Your ref:
Our ref: 22/00130/F
Please ask for: Miss Sandra Homcenko
Direct dial: 01553 616824
E-mail: borough.planning@west-norfolk.gov.uk

Details: **PROPOSED SINGLE STOREY REAR EXTENSION at The Birches Cuckoo Road
Stow Bridge KINGS LYNN Norfolk**

I have received a planning application as detailed above but cannot process it until I receive some more information:

Drawing Number: **21-P57-PL001**
Checked by: Date:

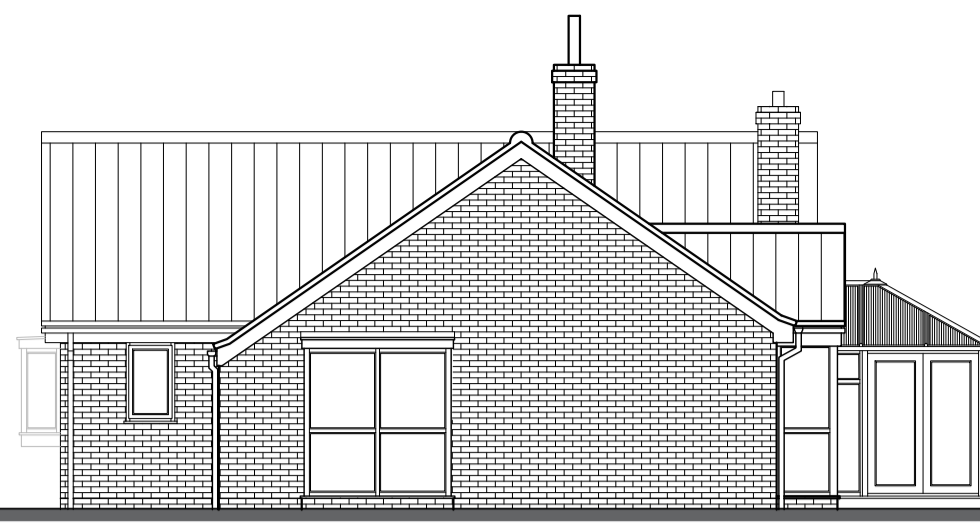
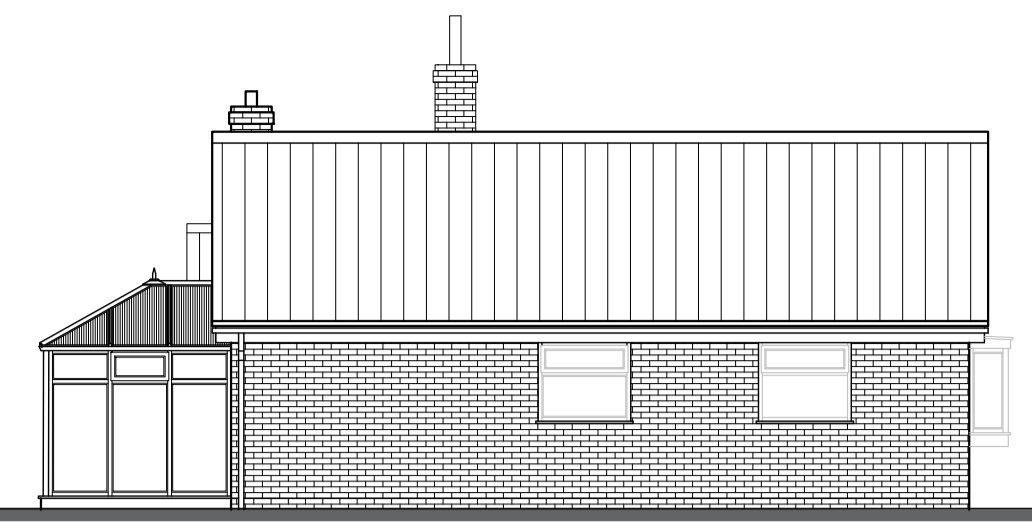
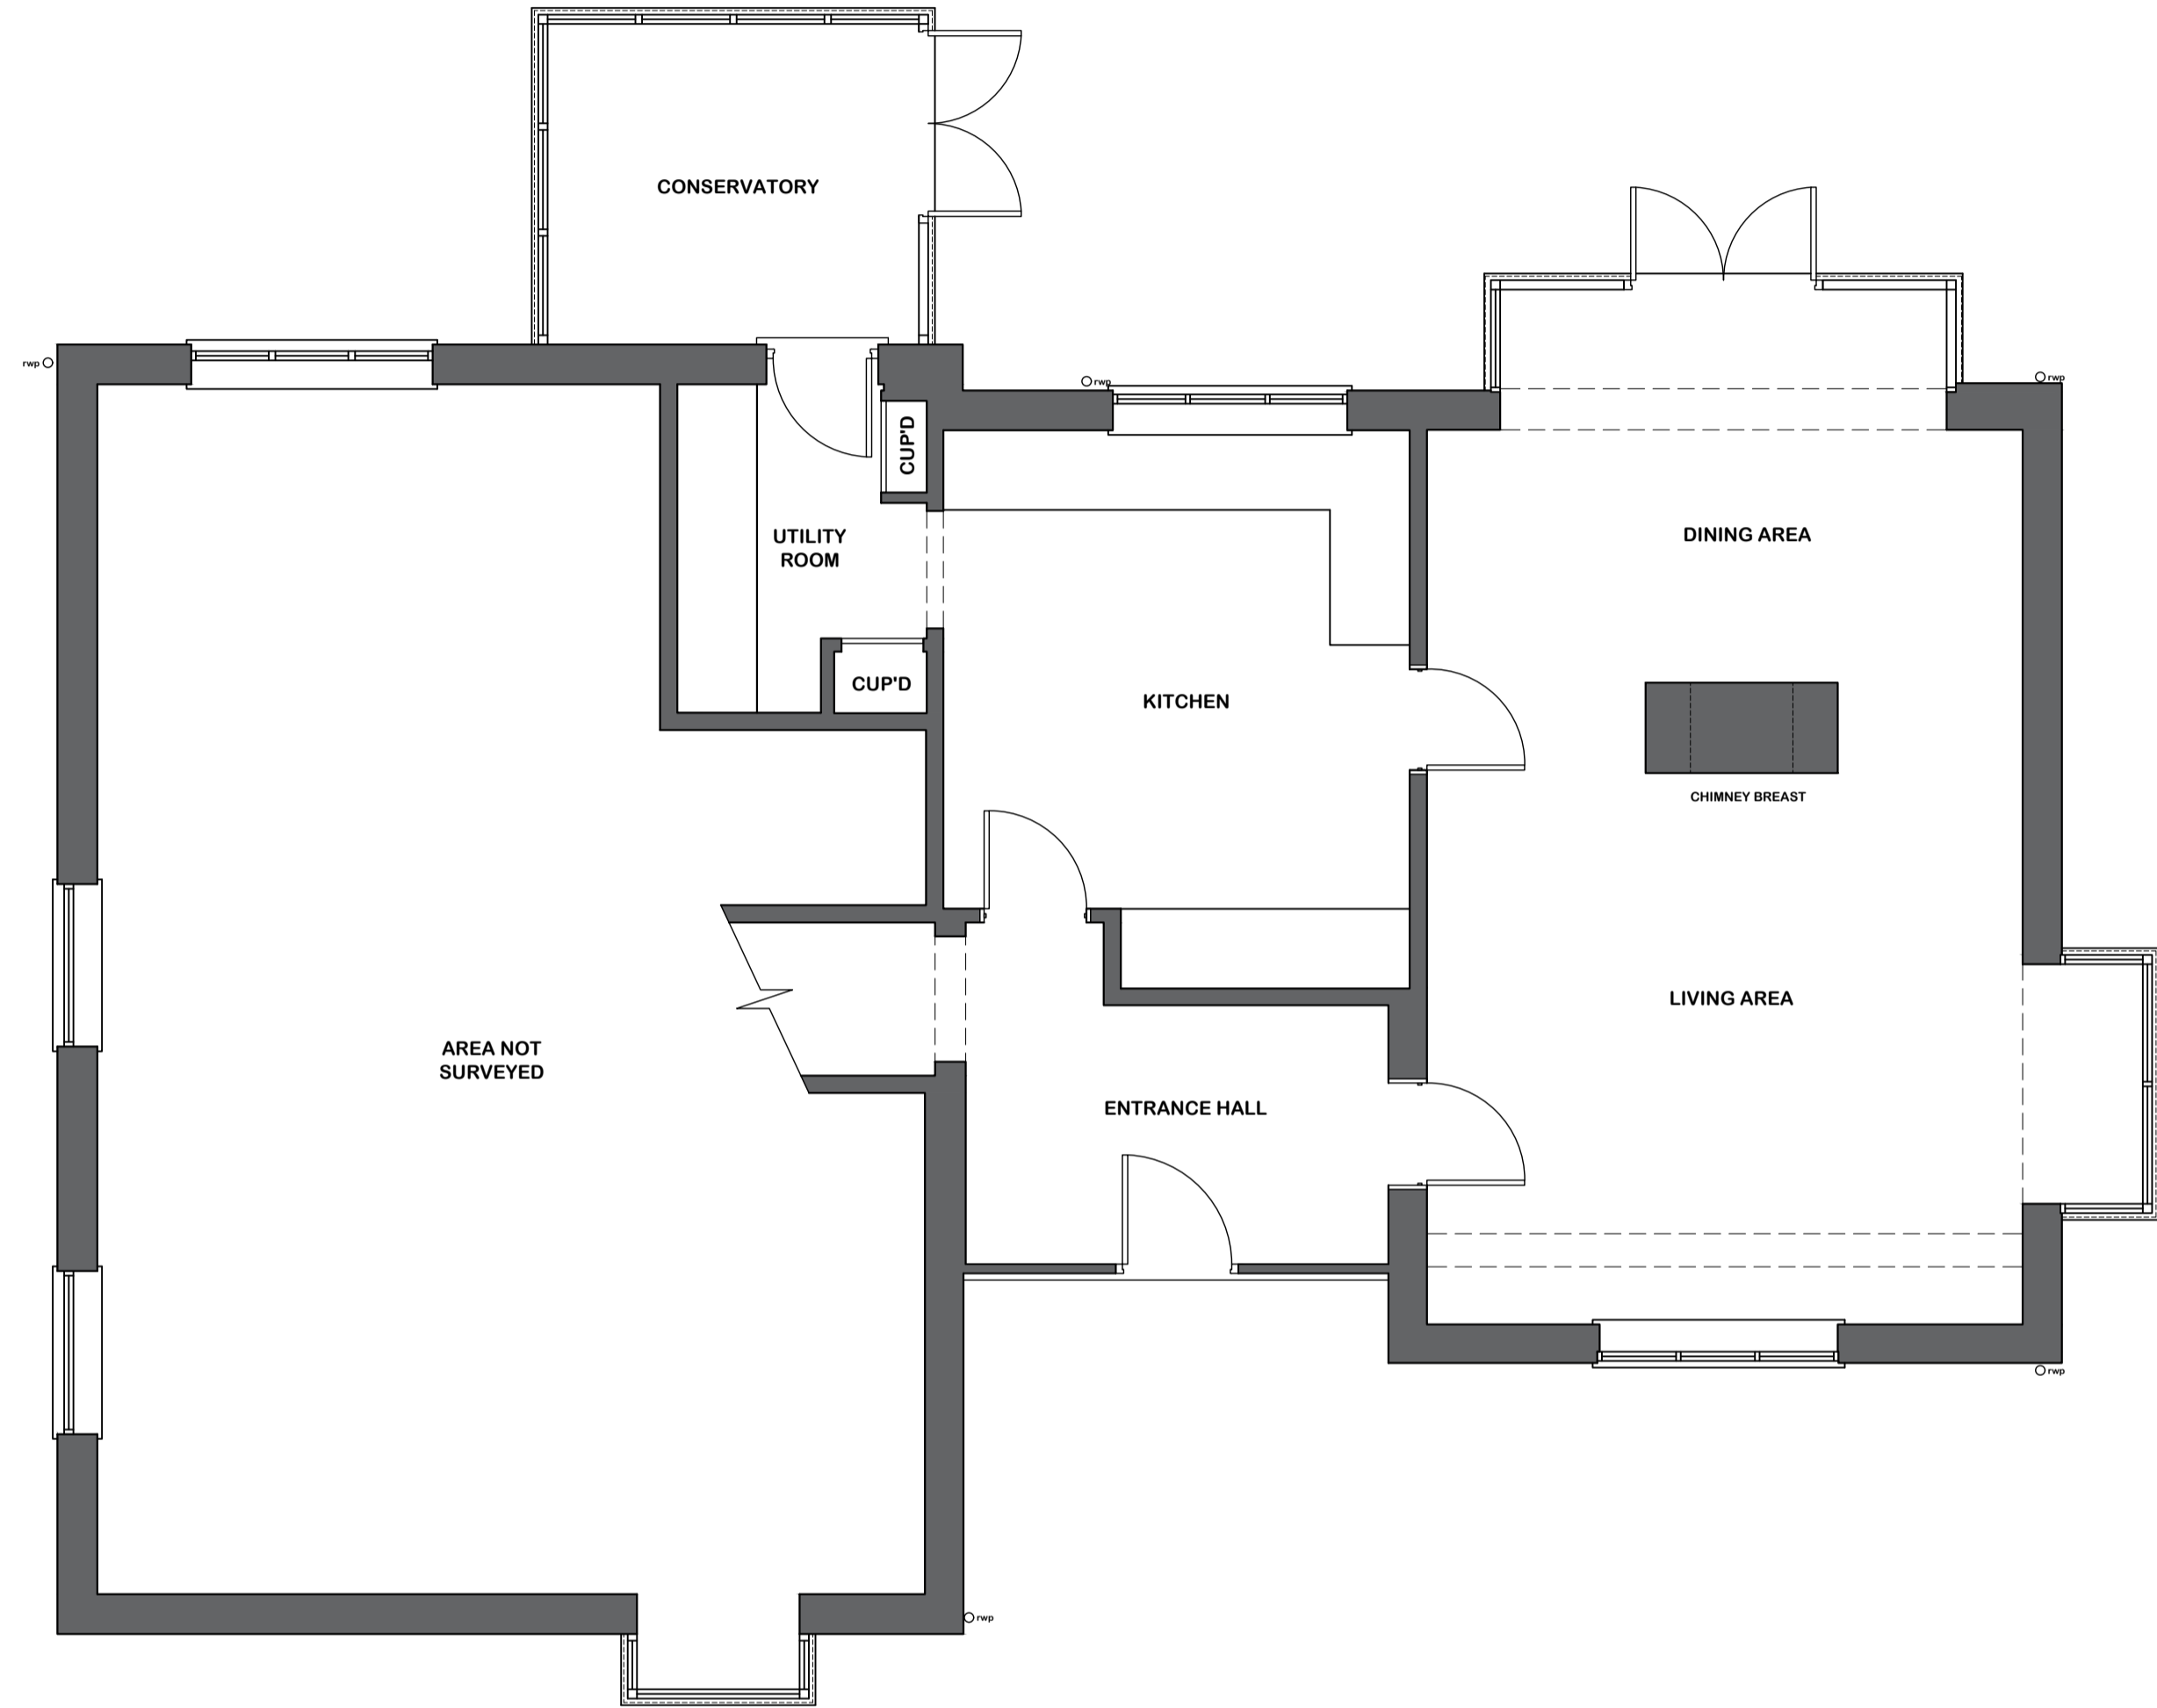
1. It appears that Existing and Proposed Floor plans do not match Elevation plans, please forward corrected plans.
